<b>Application Ref:</b>	3/2021/0003	 <b>Ribble Valley Borough Council</b> <a href="http://www.ribblevalley.gov.uk">www.ribblevalley.gov.uk</a>
<b>Date Inspected:</b>	20/01/2021	
<b>Officer:</b>	RB	
<b>DELEGATED ITEM FILE REPORT:</b>		<b>REFUSAL</b>

<b>Development Description:</b>	Erection of boundary wall, package treatment plant and two removable timber structures.
<b>Site Address/Location:</b>	Higher Greaves Barn Holden Lane Bolton By Bowland BB7 4LZ

Title	Proposed elevations		
Date	Dec 2020	Scale	1:100
Rev	0	Number	105
Drawn	SC

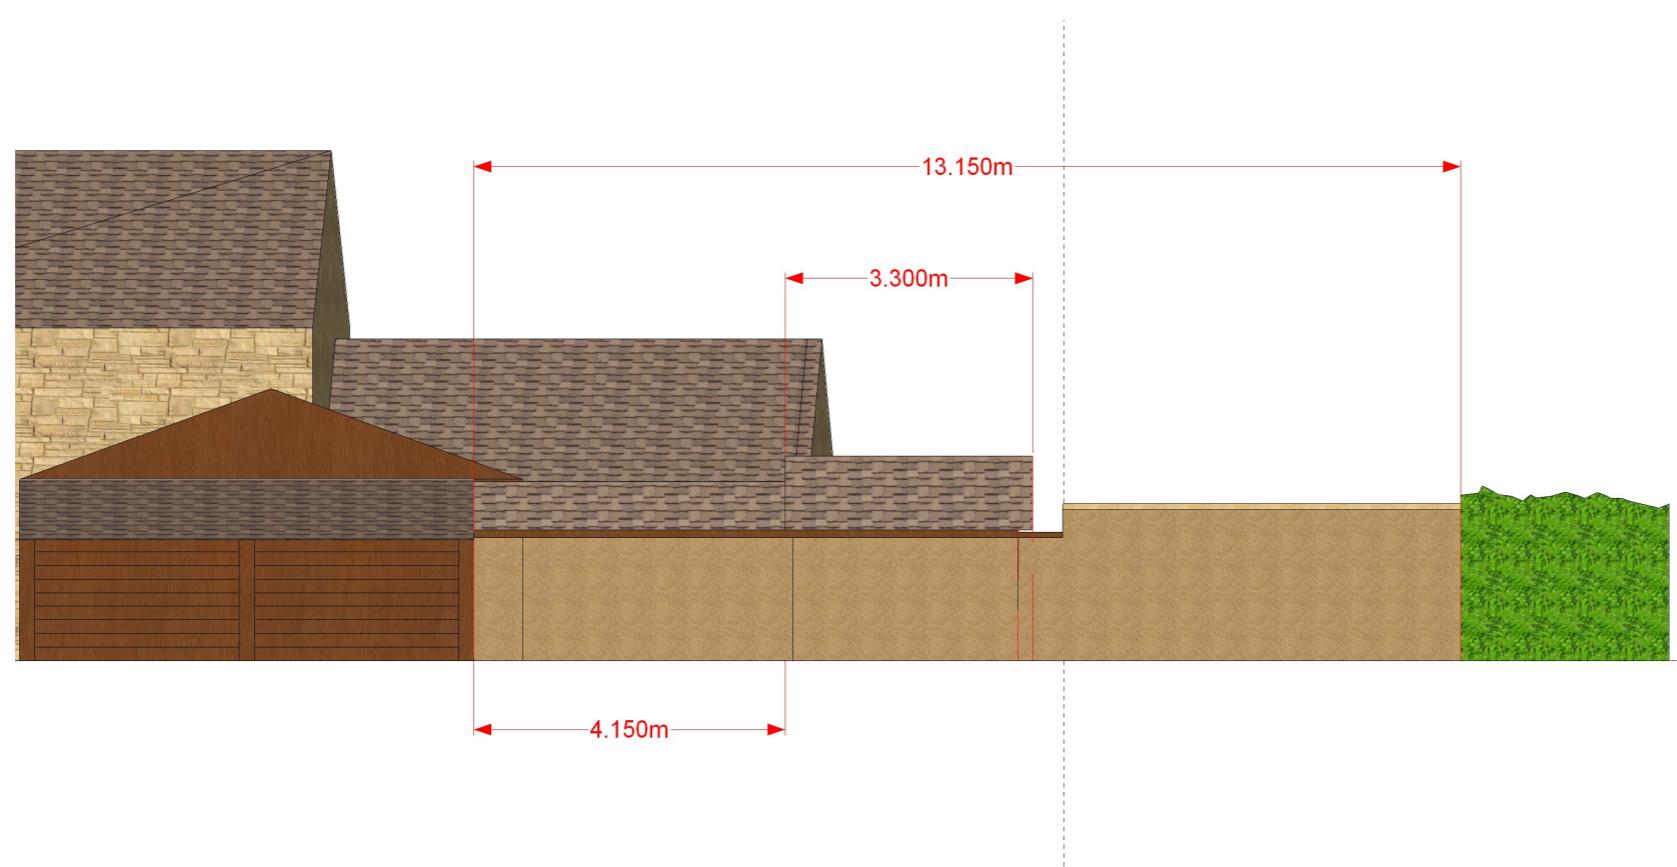
The proposed boundary wall will be sited approximately 18m from the highway, Holden Lane, and the proposed timber framed canopies are to be sited west of the wall that is proposed to be constructed. The proposed wall will have a maximum height of 2m decreasing in height to 1.7m as it continues south. The wall will be of a concrete block construction to be faced with render painted in lime white.

The proposed wall would be harmful to the character of the barn, insofar that its erection would result in an incongruous feature that would be unsympathetic to the appearance and character of the application dwelling, and it would have a harmful impact on the visual amenity of the AONB as the development site is prominent from the adjacent highway and the size, scale and appearance of the development fails to harmonise with the existing boundary treatments in the immediate locality.

The proposed 'removable structures' that will abut the timber boarded section of the wall will have an oak frame with intergray or equivalent replica flag bradstone. The use of a tile on the roof creates concern as to how 'removable' these structures are. No information has been submitted as to the purpose of these structures. Notwithstanding this it is considered that the proposed structures would further add to the domestication of the former agricultural barn in an area that was previously void of structures. It is therefore considered that the oak framed structures would also be of detriment to the character of the application dwelling.

Title	Proposed Site Plan elevations ISO		
Date	Dec 2020	Scale	1:200
Rev	0	Number	103
Drawn	SC

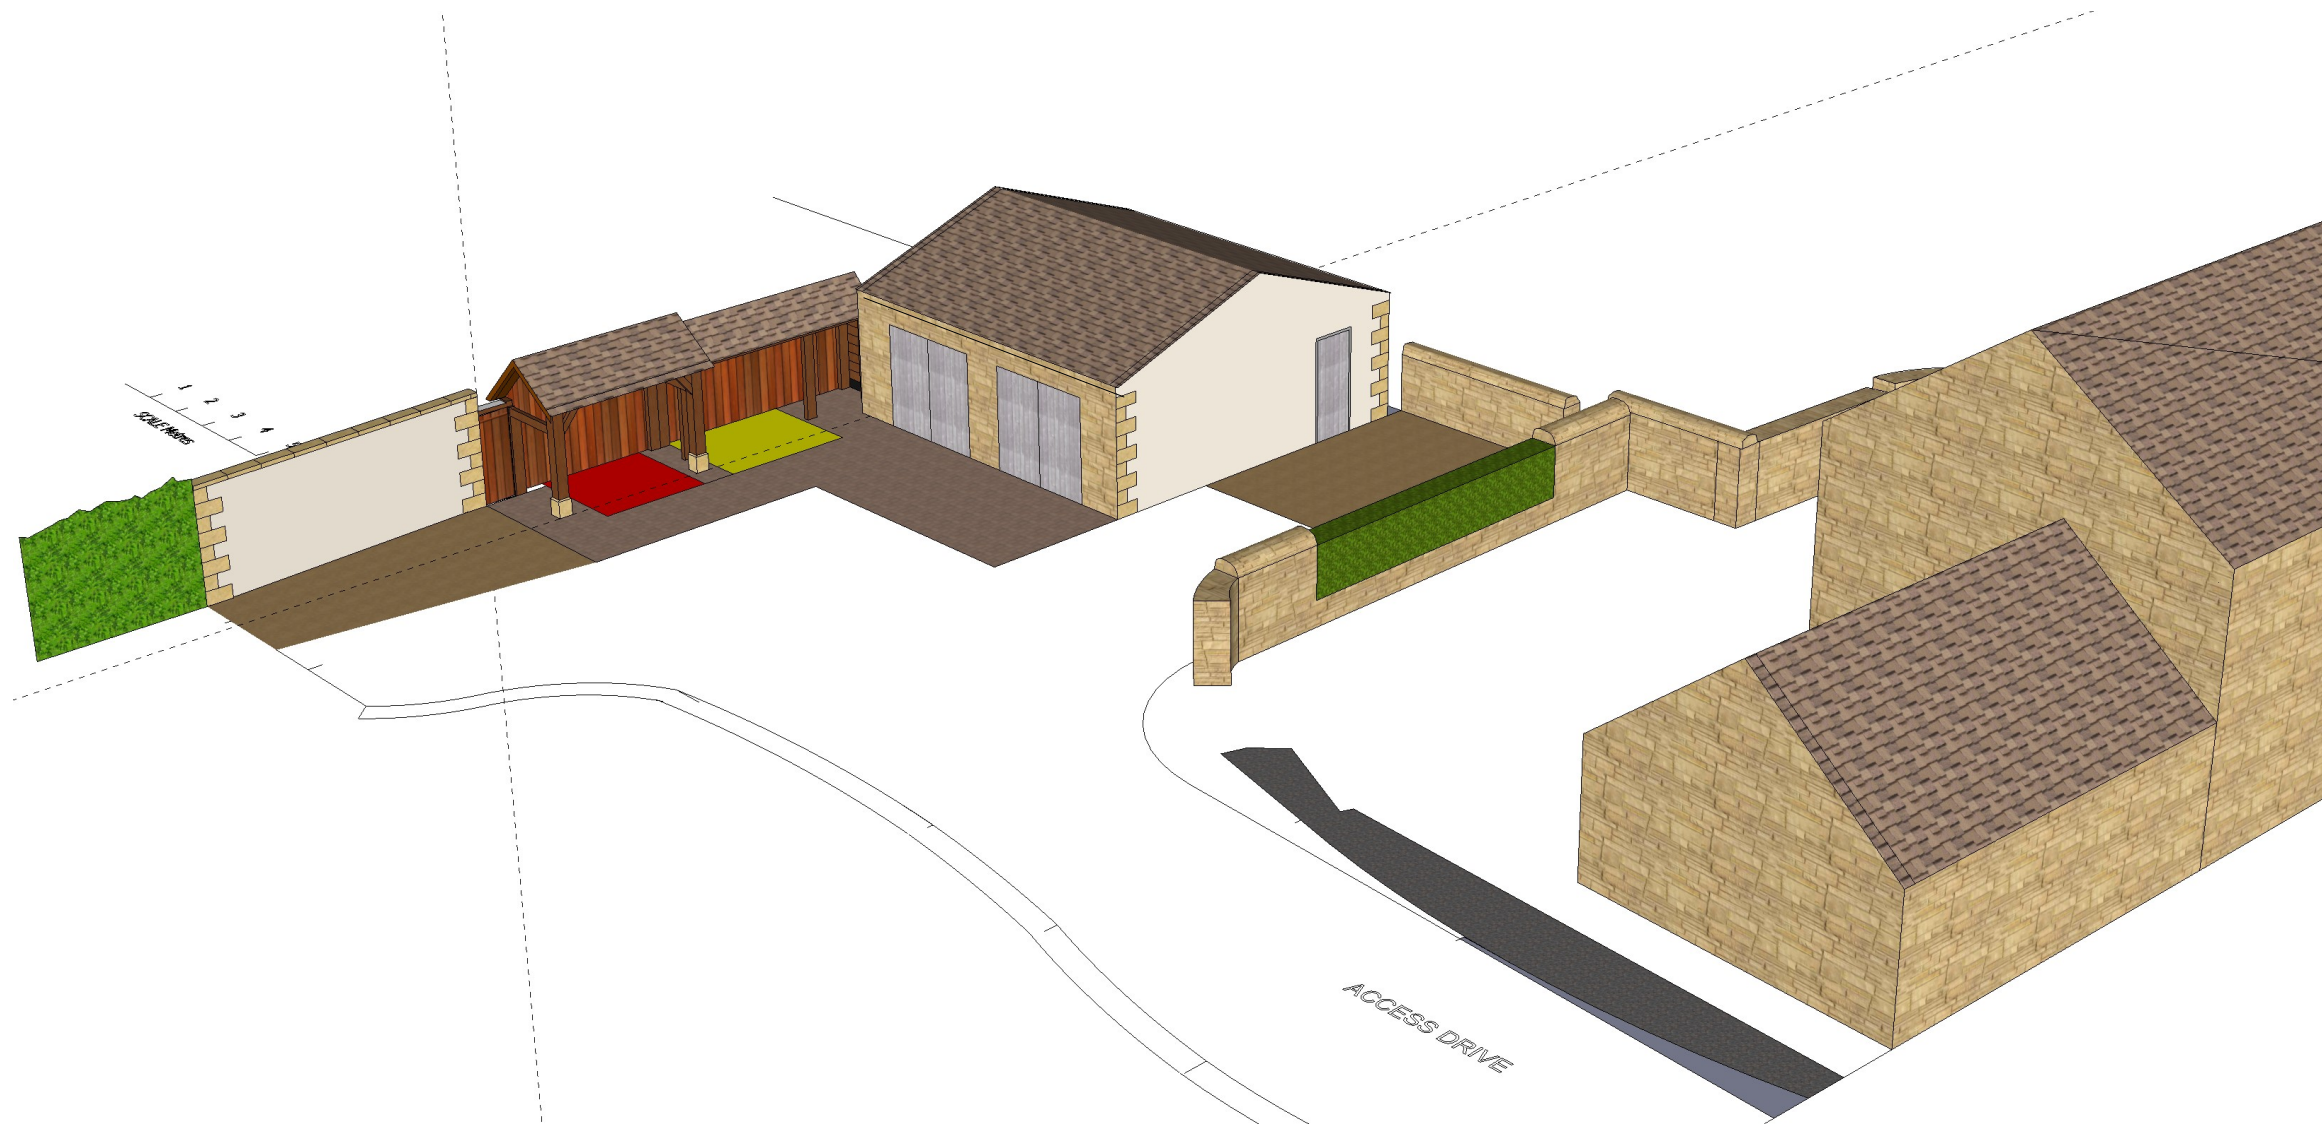
The proposed septic tank will be underground sited adjacent to an adjacent septic tank. The new tank is to be located within the driveway area of the property. It is considered that the proposed septic tank will have minimal impact on the character of the barn and visual amenity of the AONB.
